Our Ref: B3031

22 February 2022

Re: Minto Resource Recovery Facility (SSD-5339)
3 November 2021 - Request for additional information

DRAWING TITLE				
DRAINAGE DETAILS				
PROJECT NO.	PLANSET NO.	RELEASE NO.	DRAWING NO.	REVISION
P1203464	PS02	R12	PS02-E200	D

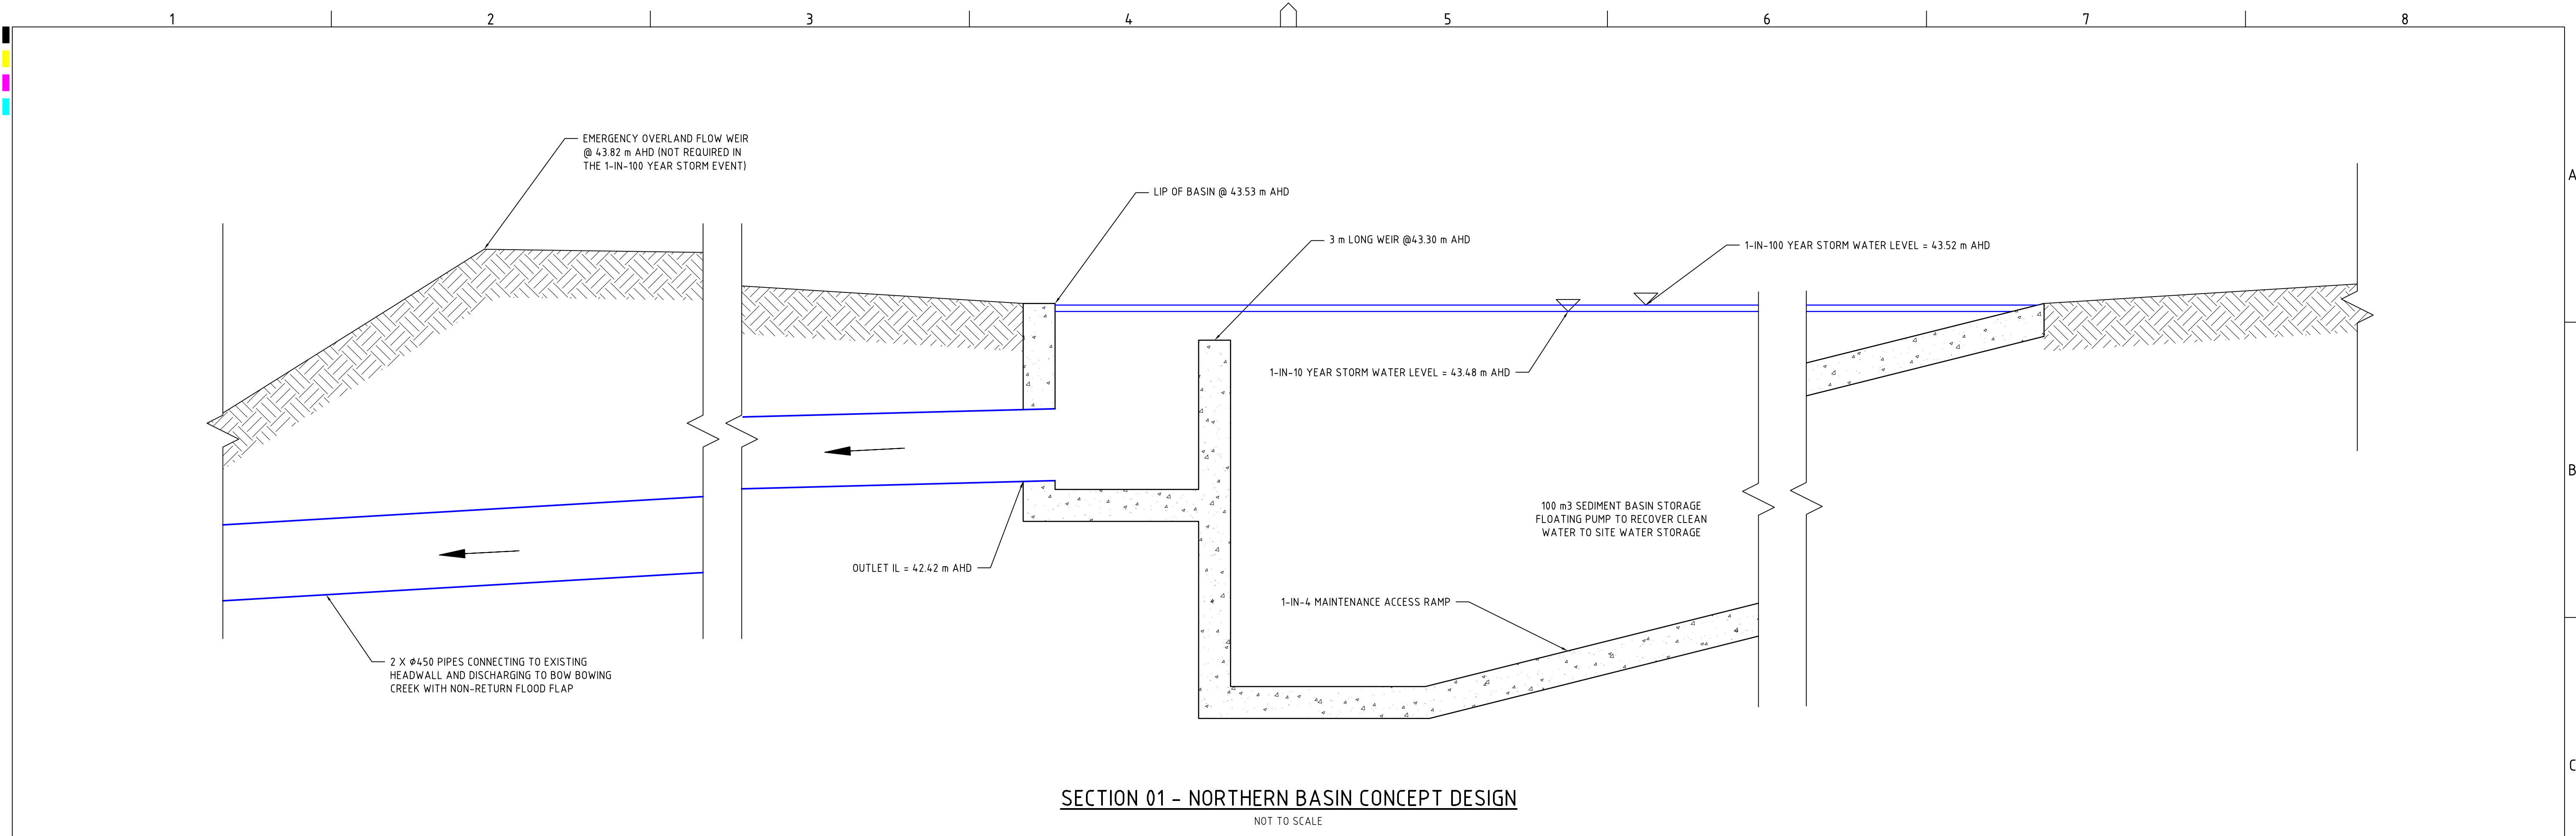
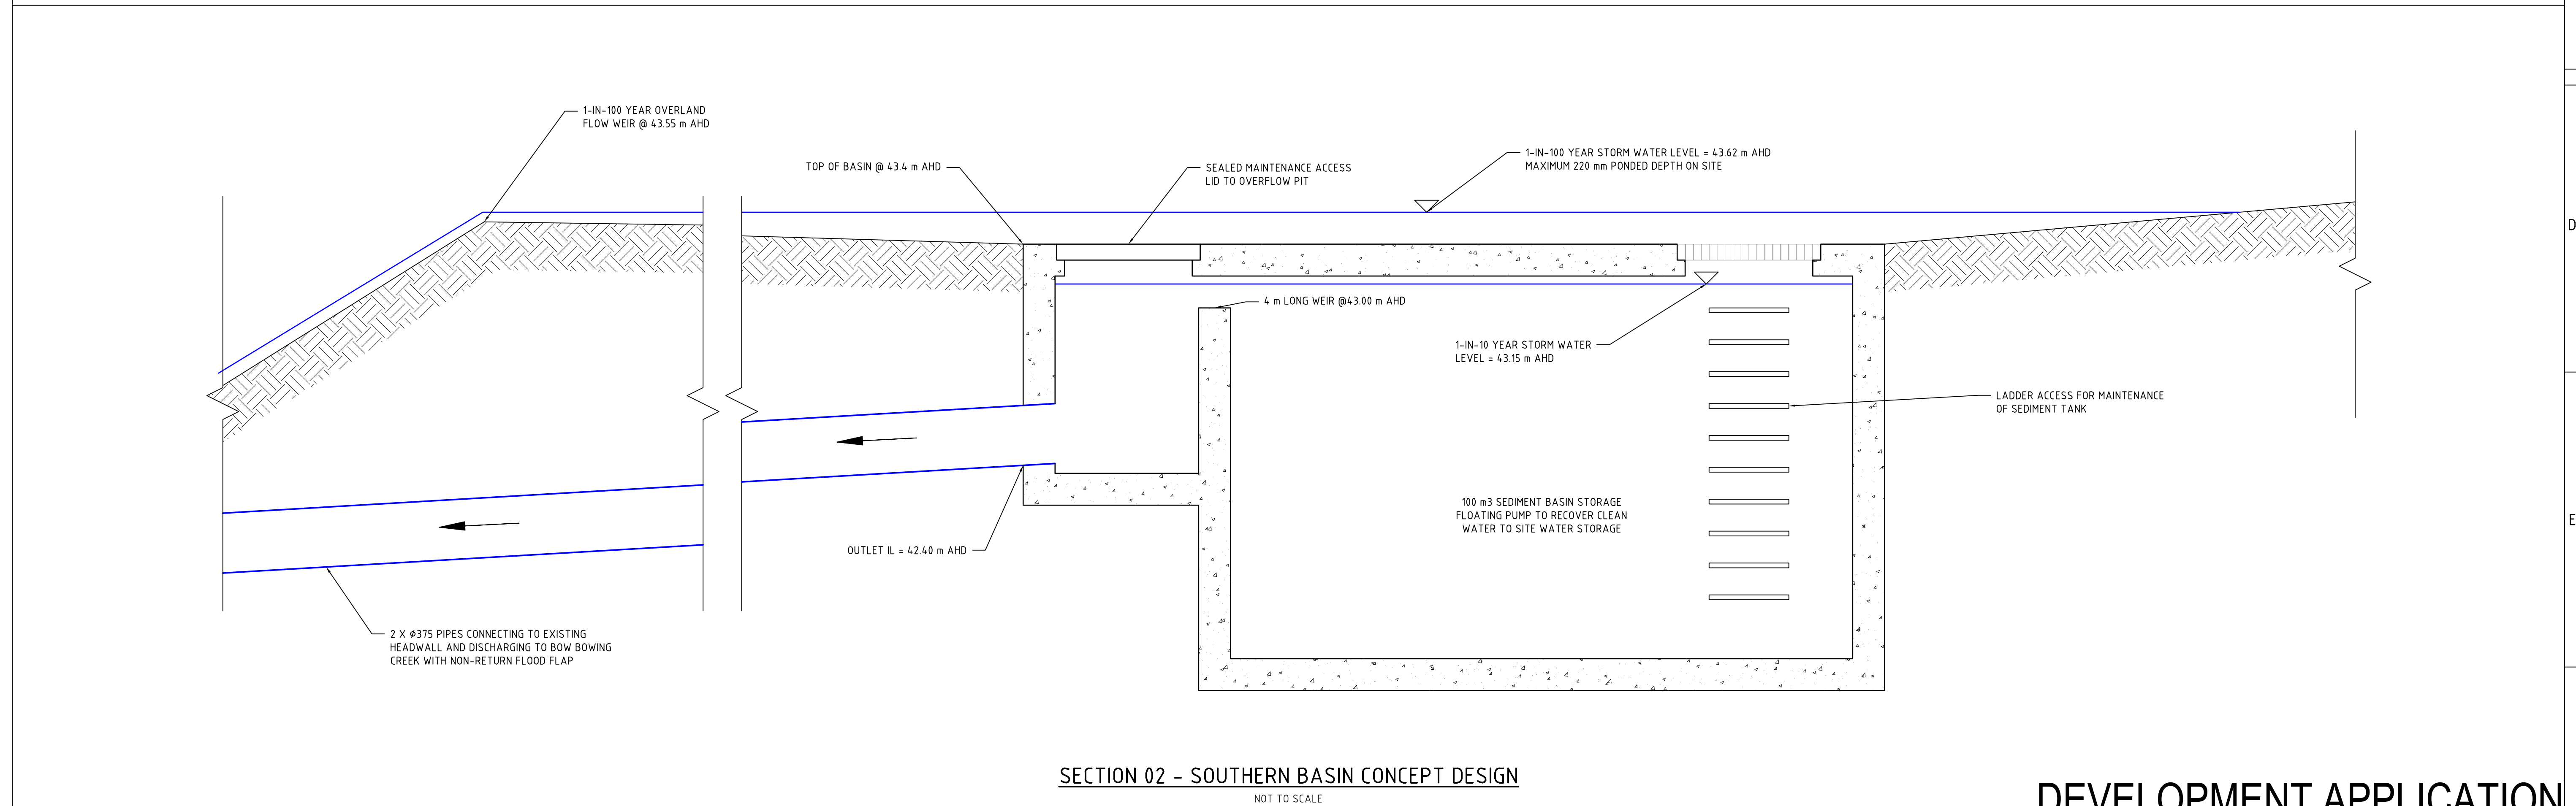
Plan PS02-A400	<p>Southern retaining wall, sand washing plant and shed moved into site by two (2) metres to allow drainage of overland flood water.</p> <p>Northern sediment basin removed and replaced with a pit and pump and an excess water storage tank (further details see Plan PS02-E100, Revision Q).</p> <p>Southern sediment basin removed and replaced with a pit and pump.</p> <p>Additional labelling as requested.</p>
Plan PS02-AZ00	Chain wire fence and clip lock fence on southern and eastern boundary replaced with concrete panel/Hebel fence.
Plan PS02-DZ01	Plan deleted.
Plan PS02-DZ02	Plan deleted.
Plan PS02-DZ03	Plan deleted.
Plan PS02-DZ04	Plan deleted.
Plan PS02-E100	<p>Northern drainage discharge removed.</p> <p>Northern water storage tank shown.</p> <p>Southern water storage tank increased to 450KL.</p> <p>Change to southern discharge to connect to existing infrastructure.</p>
Plan PS02-E200	Removal of sediment pits and replacement with pit and pump process where water is pumped into the treatment system before discharge.

DRAWING ID: P1203464-PS02-R15-DZ04

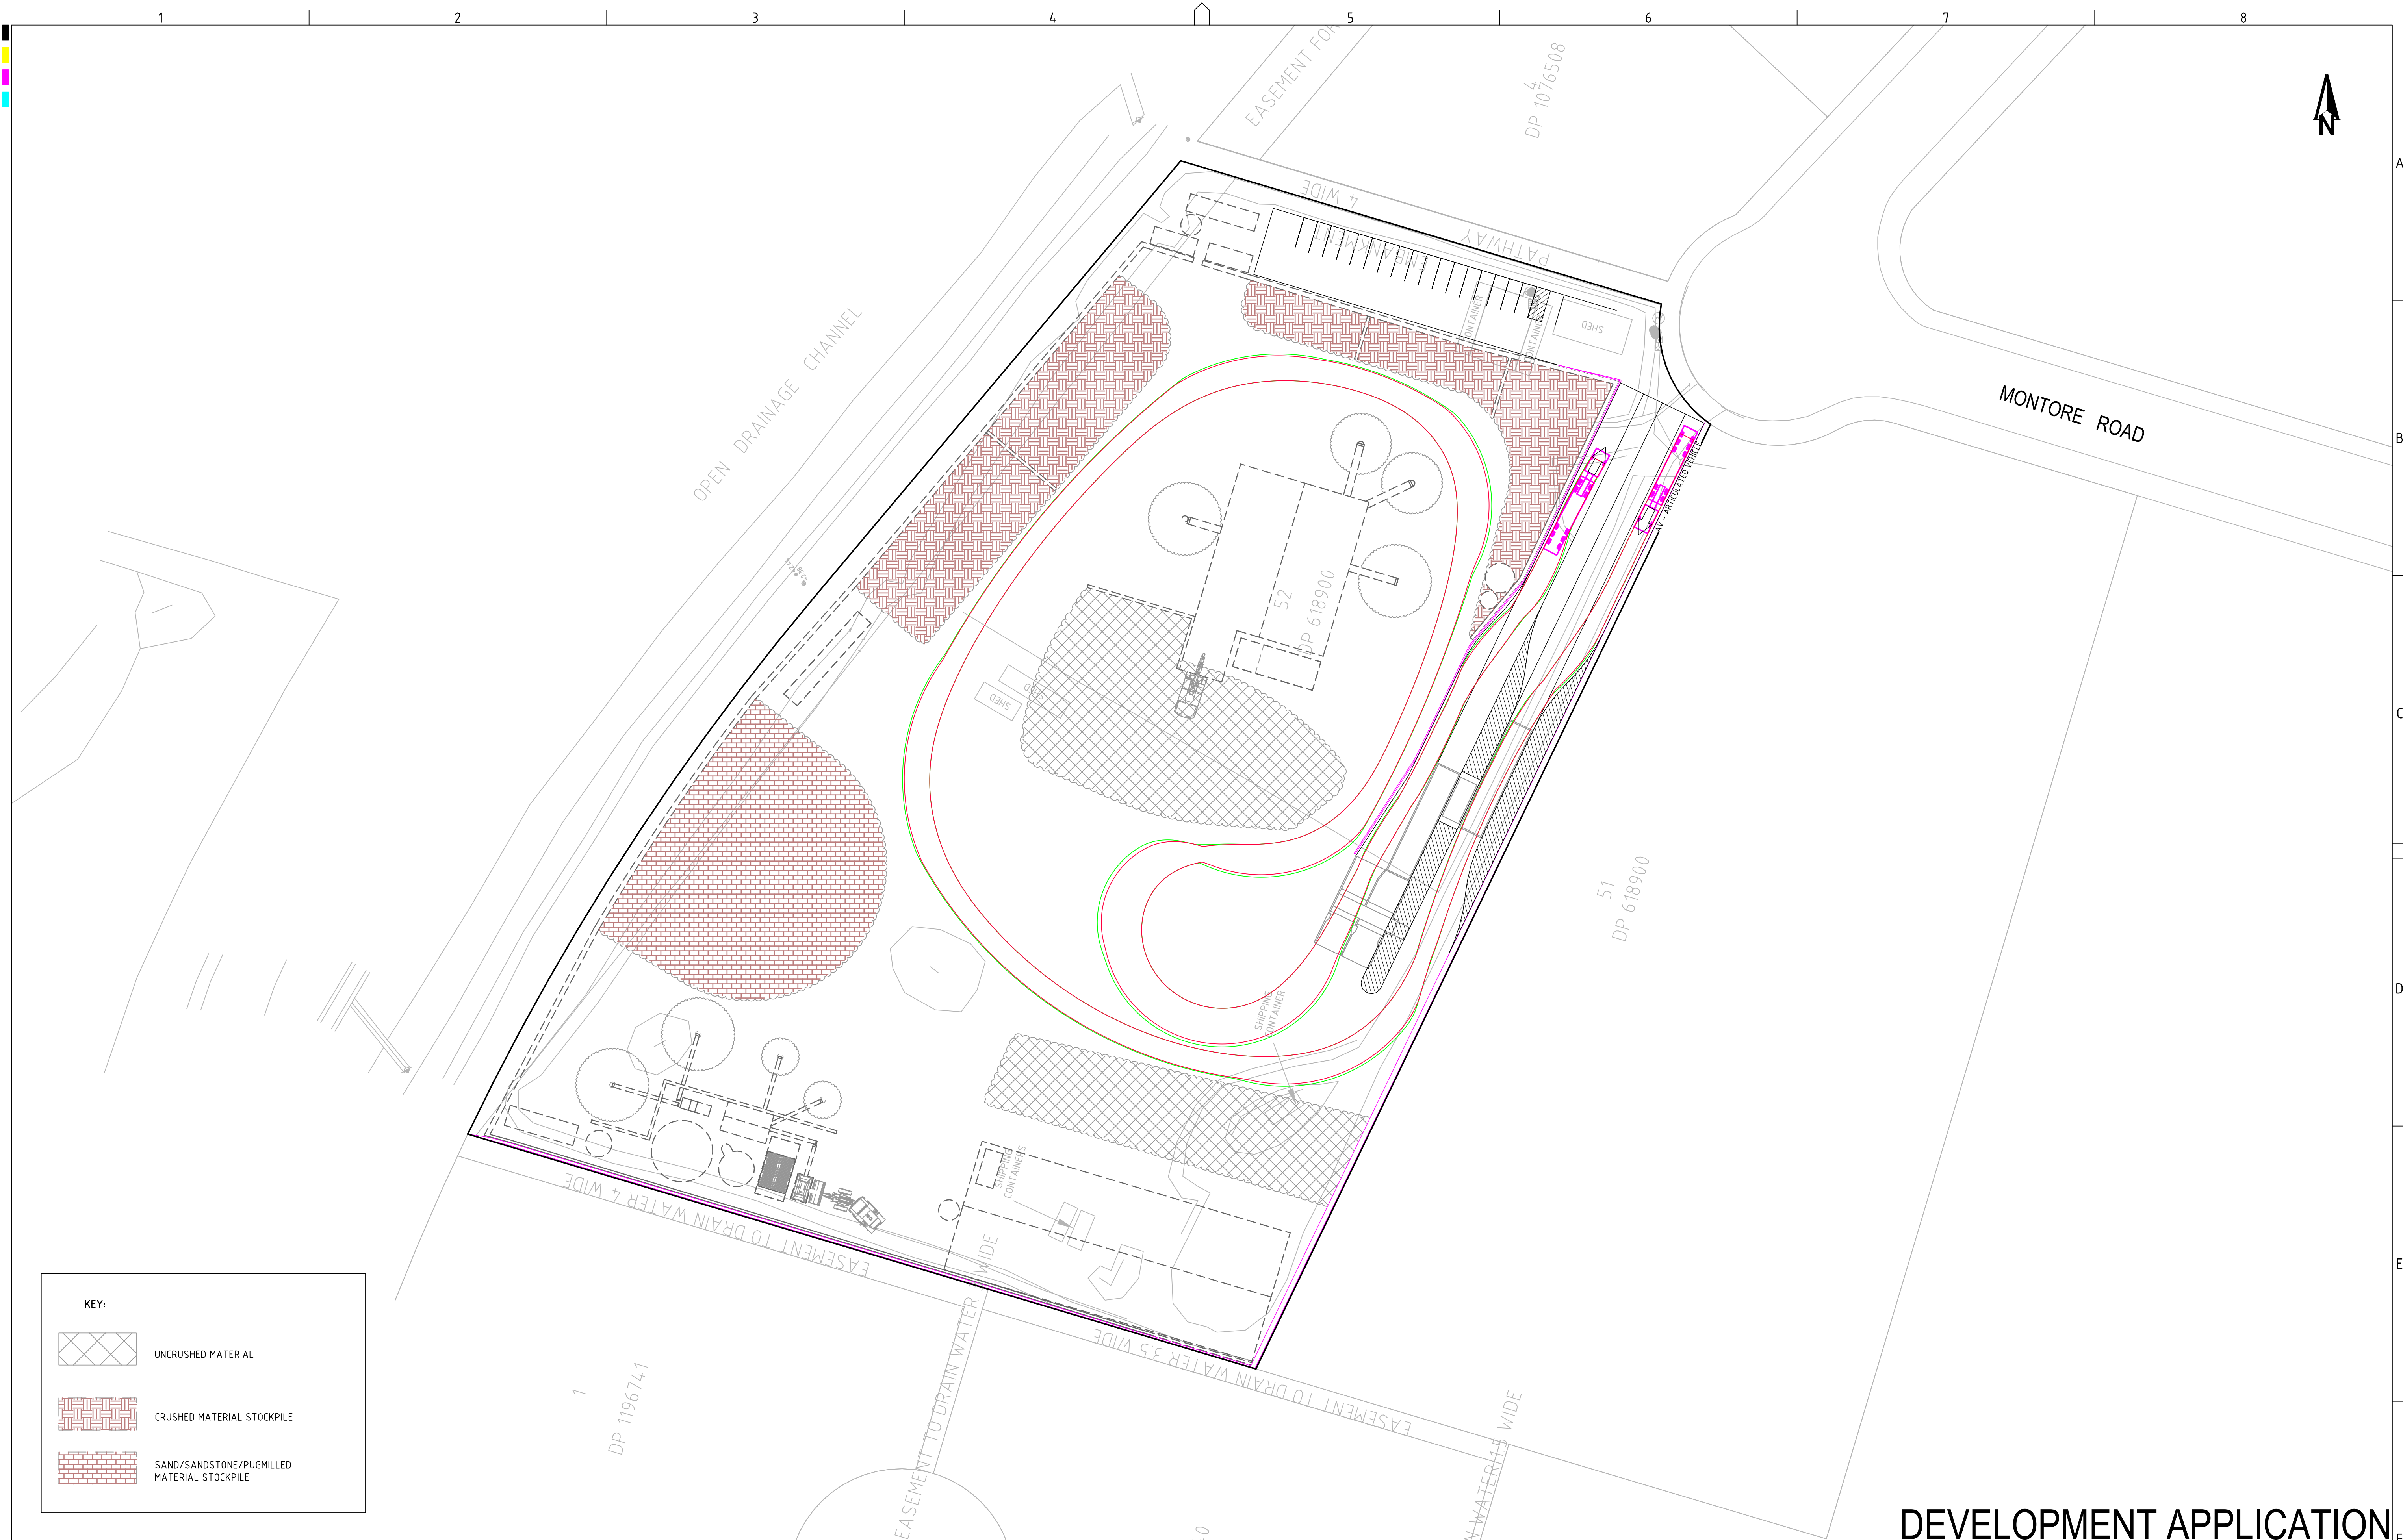
Please label the individual stockpiles on one of the plans (PS02-A401 or PS02-A400), including the stockpiles of materials from the sand washing and concrete crushing plant.

The label should describe the waste or product they hold.

The RTS states that stockpiles adjacent to the boundary of the site will be 6 m but the stockpile layout plan, Drawing No. PS02-A401, states stockpiles C and D will be 8 m, please clarify.

Drawing PS02-A401 has been modified as required, refer Revision C. A complete set of the modified plans is provided as **Attachment 6**.

Drawing No.PS02-A401 has been modified to state that Stockpiles C and D will be 6m in height.
